**RE: De Anza**  
**Grading Plan and Drainage Master Plan**  
**Stamp Date: 10/22/17**  
**Hydrology File: K17D106**

Based upon the information provided in your submittal received 12/18/2017, the Grading Plan and Drainage Master Plan is not approved for Building Permit. The following comments need to be addressed for approval of the above referenced project:

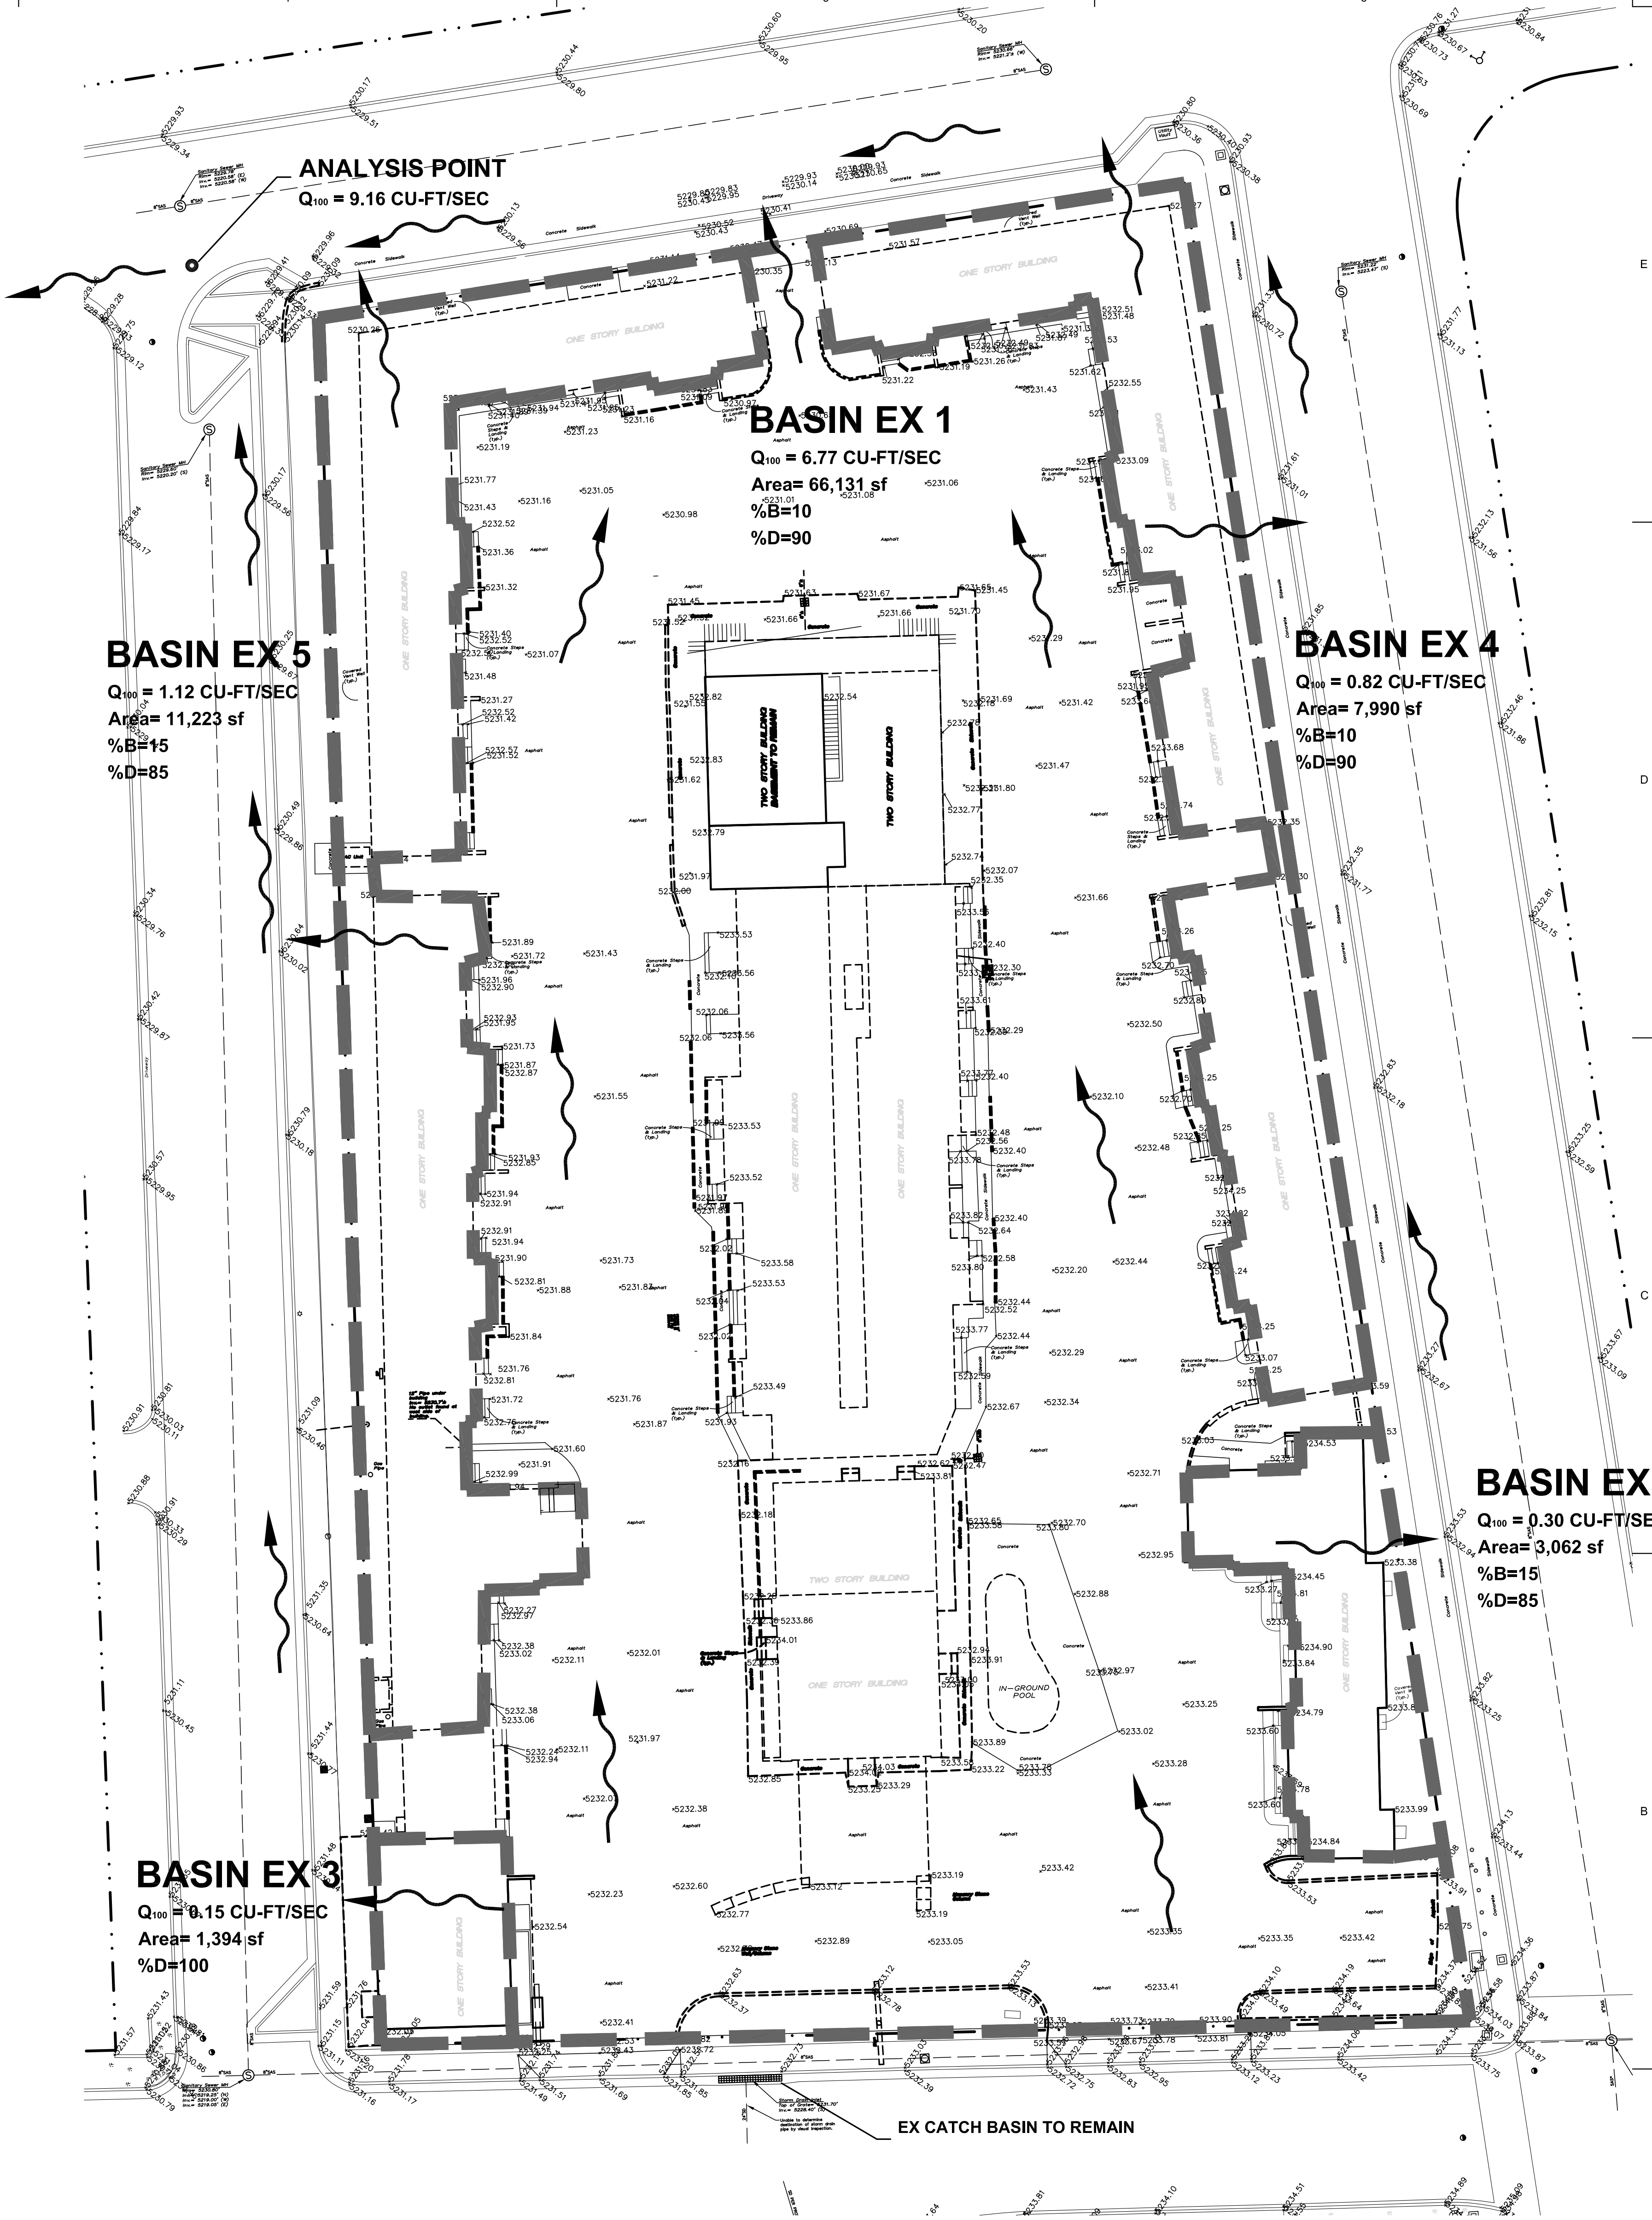
1. Please provide an engineer's stamp with a signature and date on all sheets.
2. Please place engineering drawings on a maximum paper size of 24"x36".
3. Sheet CD1. Please change the title to "Drainage Management Plan".
4. Sheet CD2. Please label all the builds with the proposed building letters.
5. Sheet CD2. Please label the first flush ponds with the provided volume.
6. Sheets C-201, C-202, & C-203. These are duplicate sheets. There are no new information on these sheets. Please remove sheets.
7. Sheet C-204 thru C-212. The isometric drawings provided show no new information. Are these necessary? Also the proposed grades are very hard to read. If these are to stay, then make the proposed grades readable.
